About the application

Application number: 2024/91643	
What is the application for?:	Erection of rear balcony and formation of new opening
Address of the site or building:	26, Shaw Lane, Holmfirth, HD9 2AD
Postcode:	HD9 2AD

Proposed North East Facing Rear Elevation  
Scale 1:50

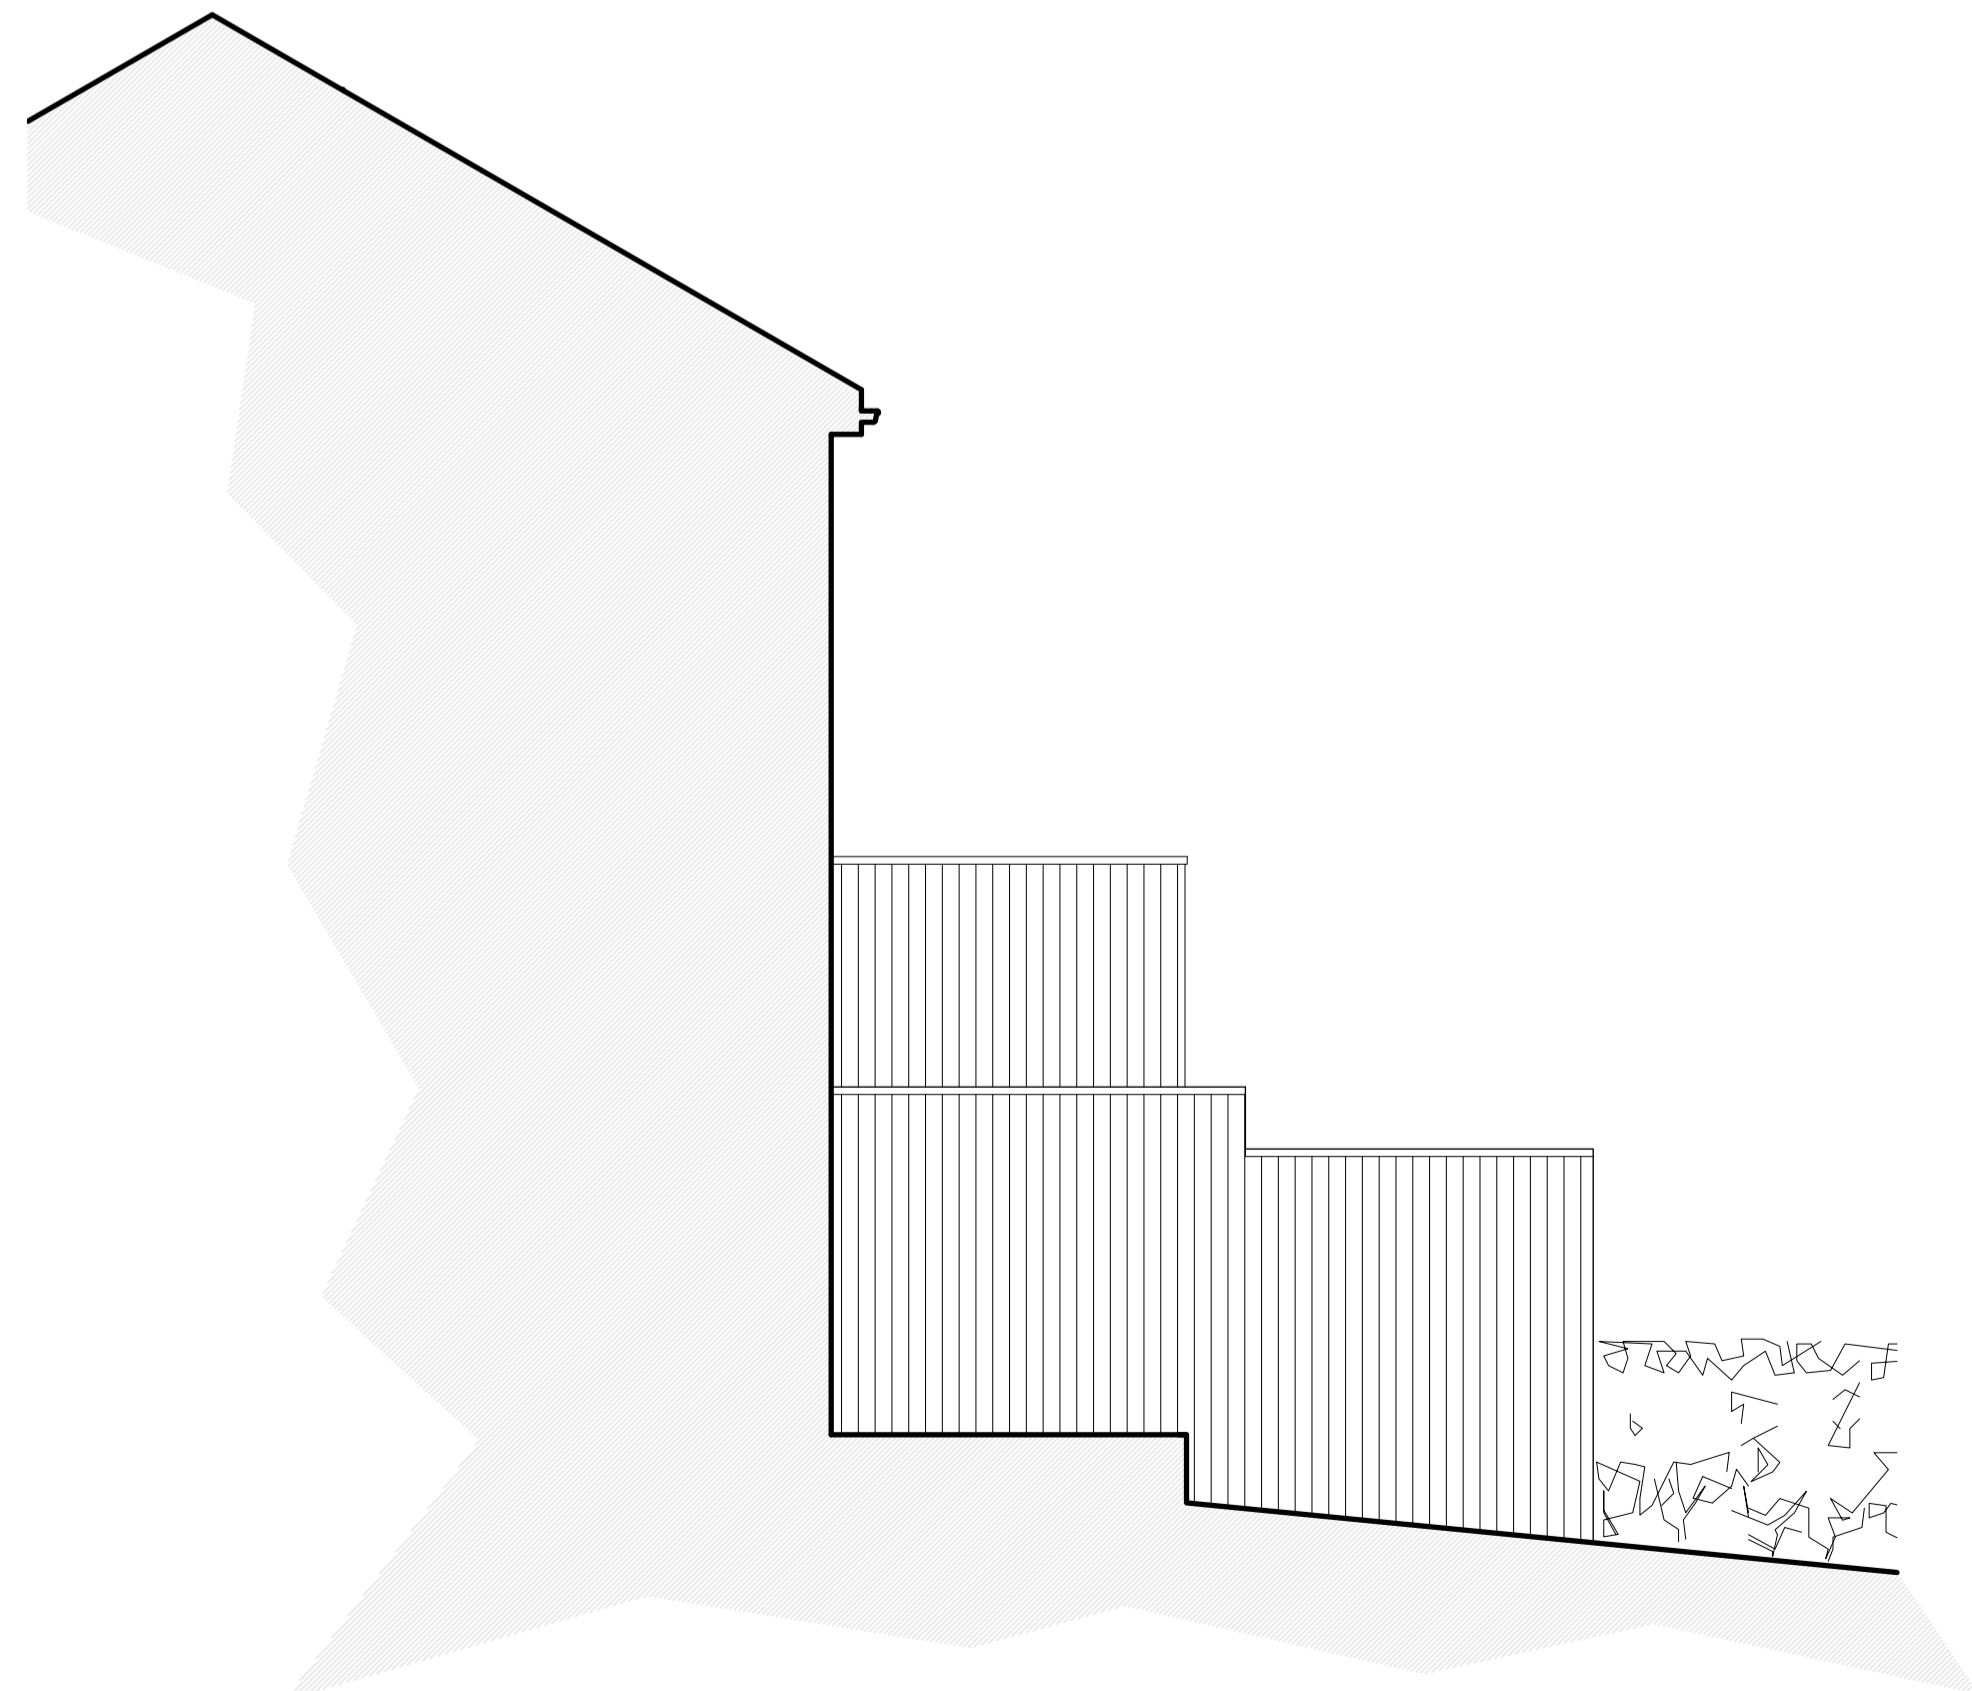
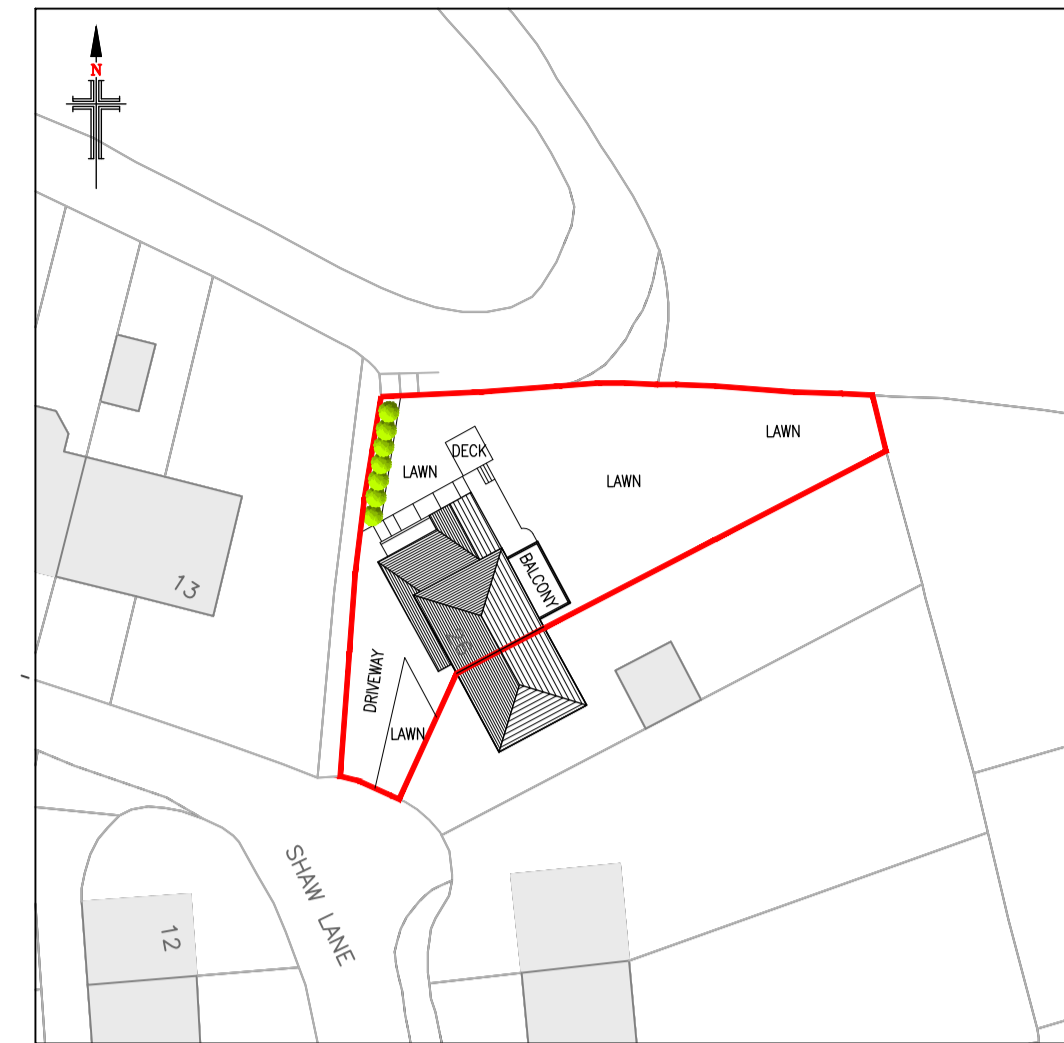
Type of comment: An objection	
Do you wish your comments to be published on the website anonymously?	Yes
Application Number 2024/91643	
<p>I am concerned that the size and placement of the proposed balcony and fencing will impact negatively on the quality of our living experience, specifically the view from the rear of our property and the dining room in particular. We purchased our property based on the view and outlook, and have subsequently built our living experience around the dining room and dining room window. I believe this experience will be diminished by the proposed balcony, and I will be saddened by a development that restricts our access to the current outlook and view.</p> <p>There is also concern that sound spill from such a large open area leading from the property would effect ambient noise levels and cause disturbance.</p>
